HINCKLEY NATIONAL RAIL FREIGHT INTERCHANGE

Applicant's response to Deadline 5 Submissions [part 4 - WCC]

Document reference: 18.19

20 February 2024

Drawing file: TR050007 / TR050007-002505-Hinckley NRFI Appendix 14 - Gibbet Hill Mitigation General Arrangement.pdf

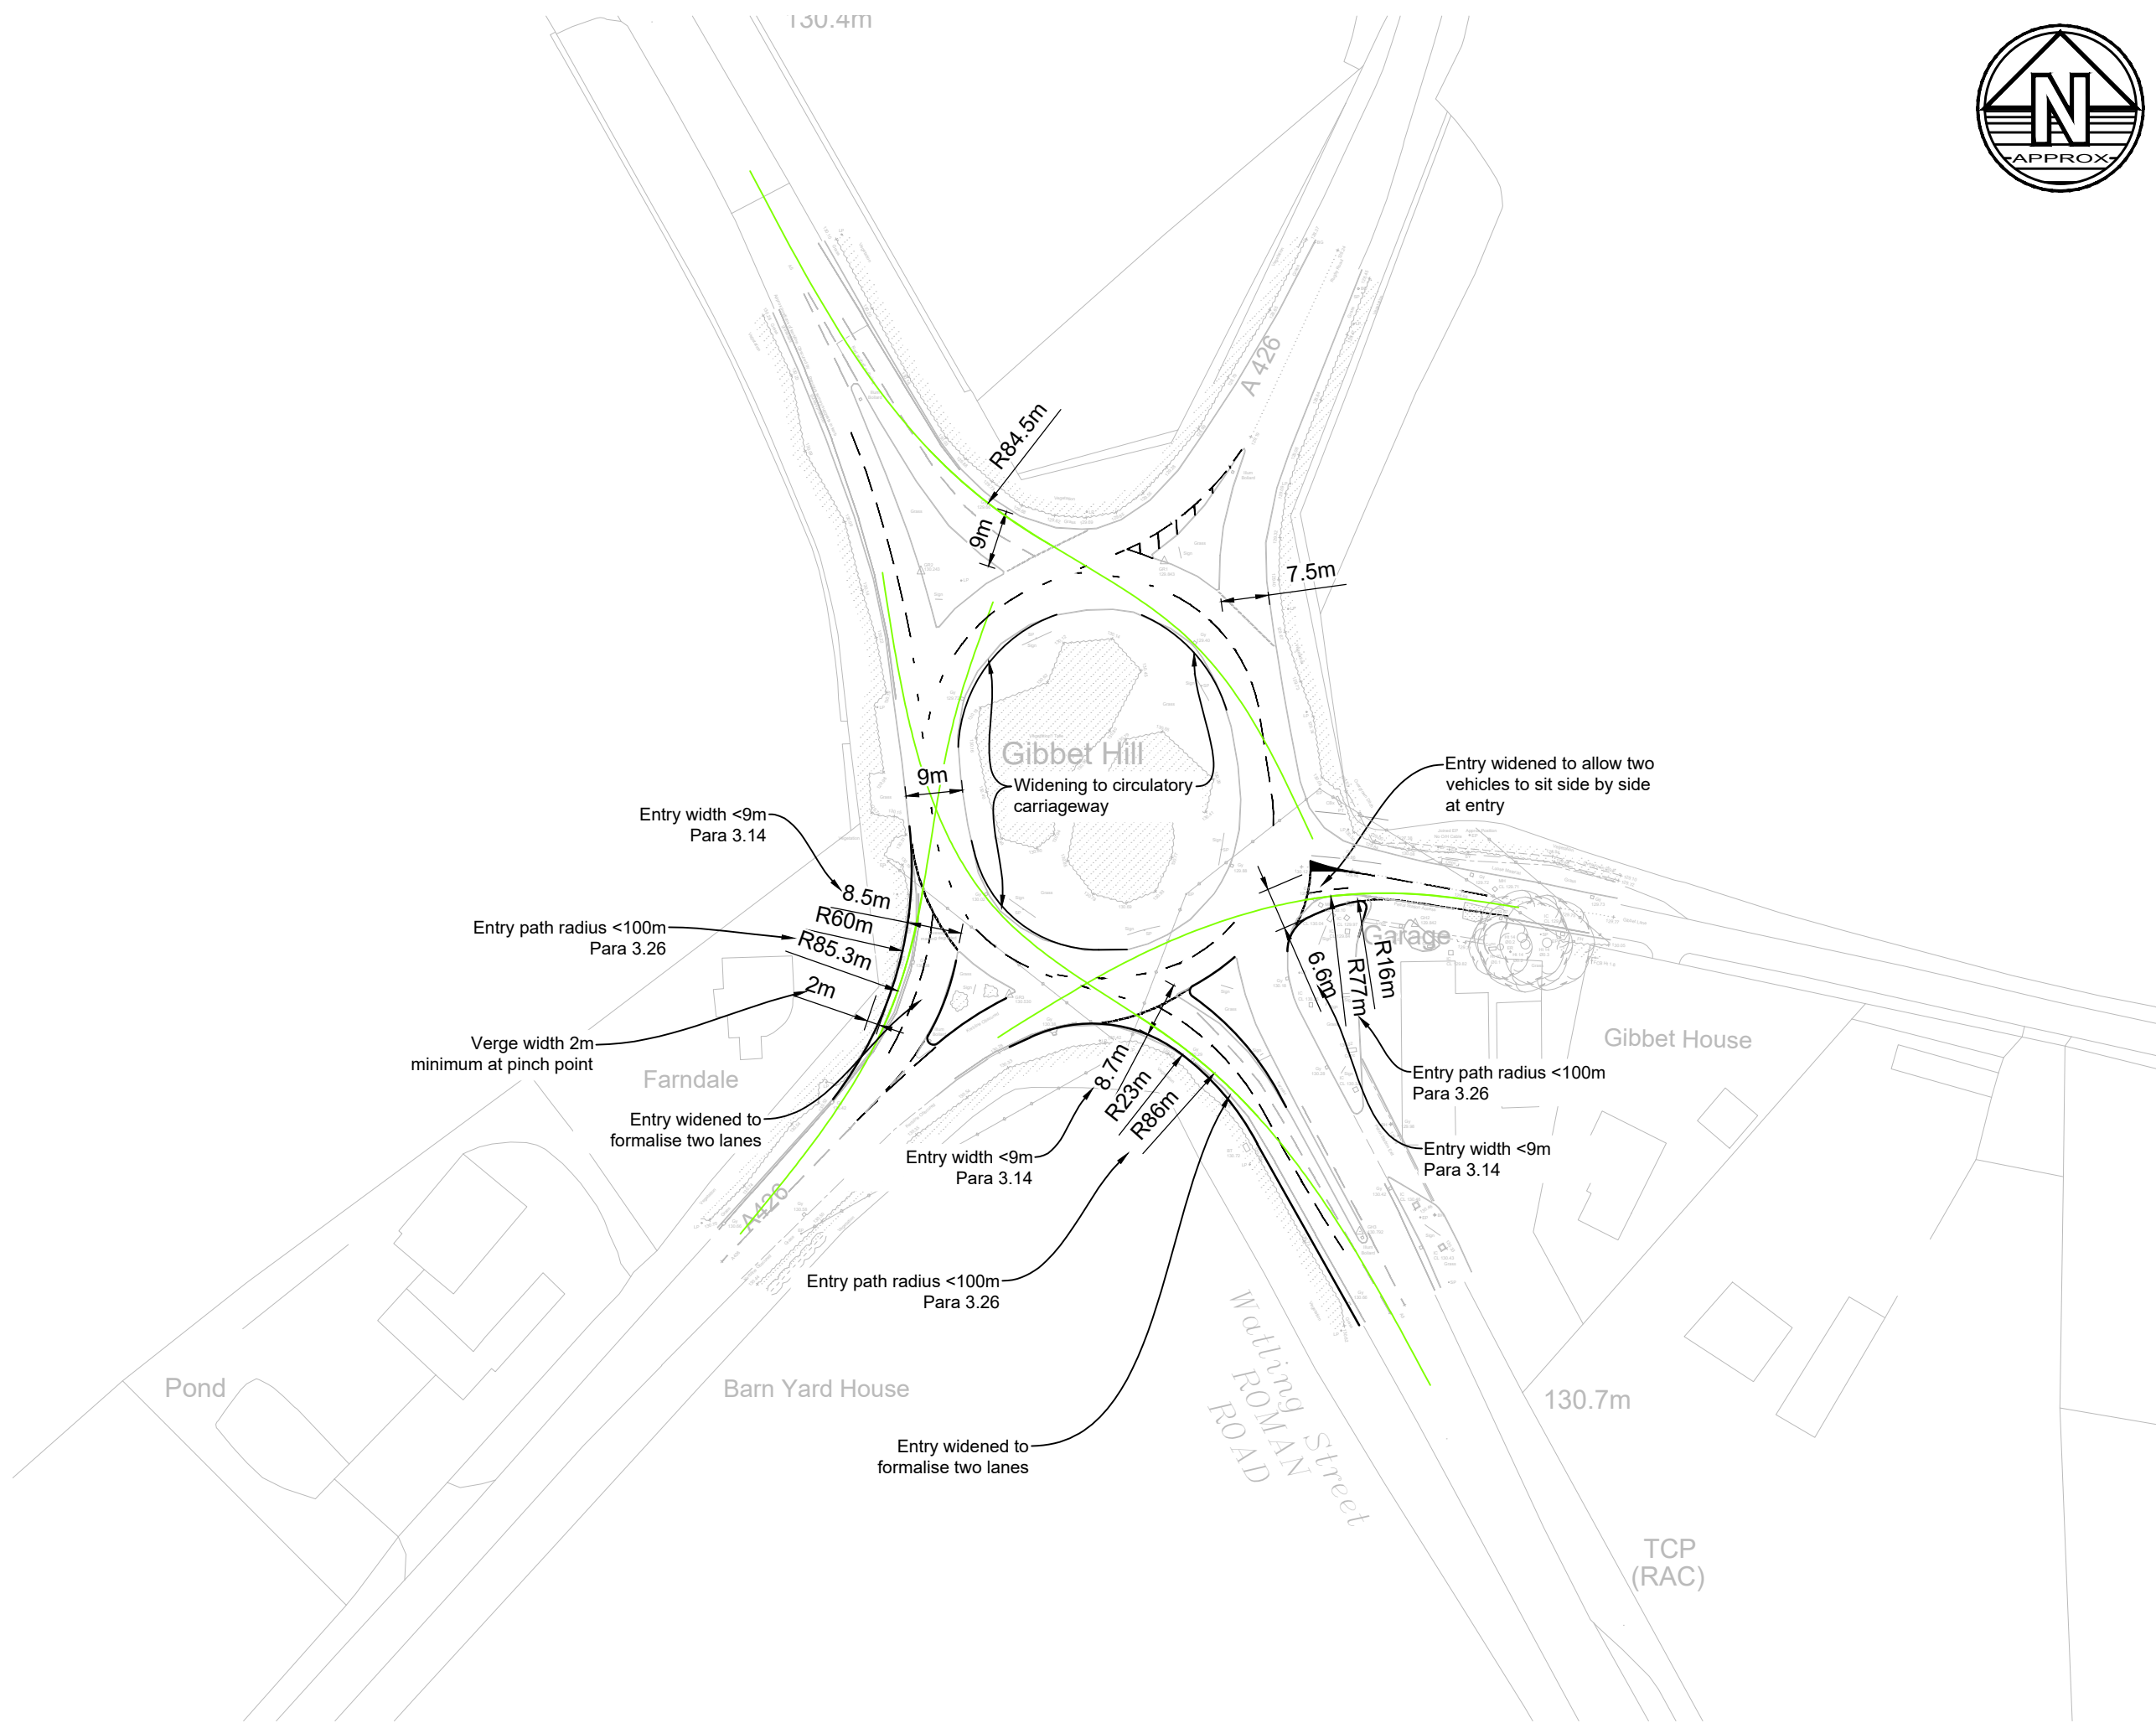
Examination Ref	Question	WCC Response	Applicant's Response
		<p>necessarily be suitable to address the true impacts of the development.</p> <p>WCC will continue to discuss this issue with the applicant and will update at each Deadline.</p> <p>It is noted that to date a VISSIM assessment of Gibbet Hill has not been carried out by the applicant. WCC's previous comments from Deadline 1 are listed below and these set out why an assessment is necessary to enable a CIL compliant decision to be made in respect of any potential contributions in mitigation of development impacts.</p> <p>3.21. → Whilst BWB has noted in its response to point 19 in HNRFI-BWB-GEN-XX-RP-TR-0031-Rev-P01 that there is not full correspondence between the 18 entry points identified within the VISSIM model and the traffic flows derived from PRTM, Warwickshire County Council consider that it is still important for the VISSIM to be used to assess development impact for the reasons set out below:¶</p> <ul style="list-style-type: none"> • → National Highways does not have a committed scheme at this junction as highlighted previously and therefore the baseline position for the modelling must be the existing non-signalised junction arrangement (i.e., a Do-Nothing)¶ • → Blocking back towards M6 Junction 1 along the A426 and platooning of traffic between M6 Junction 1 and the Gibbet Hill junction can only be considered within the VISSIM model¶ • → Whilst Warwickshire County Council understands that flow correspondence may only exist across 8 loading points, we do not necessarily consider this to be a limitation which invalidates the use of the VISSIM model¶ • → For example, if the loading points within the VISSIM model which correspond to the PRTM data include the A5 (2), the A426 north and south (2) the M6 (2) and Gibbet Lane (1) then there is sufficient network correspondence to assign the development trips across the study area from the PRTM outputs¶ • → Warwickshire County Council does not require the interaction on the minor roads (i.e., Lutterworth Road or Arthur James Drive) to be considered in terms of changes in development flows and, as such, impacts at these locations can still be considered, particularly in the context of the effects arising from delivery of any proposed mitigation at Gibbet Hill.¶ <p>3.22. → Therefore for these reasons Warwickshire County Council does not accept the modelling or proposed mitigation at this location, and requires the VISSIM modelling to be carried out.¶</p>
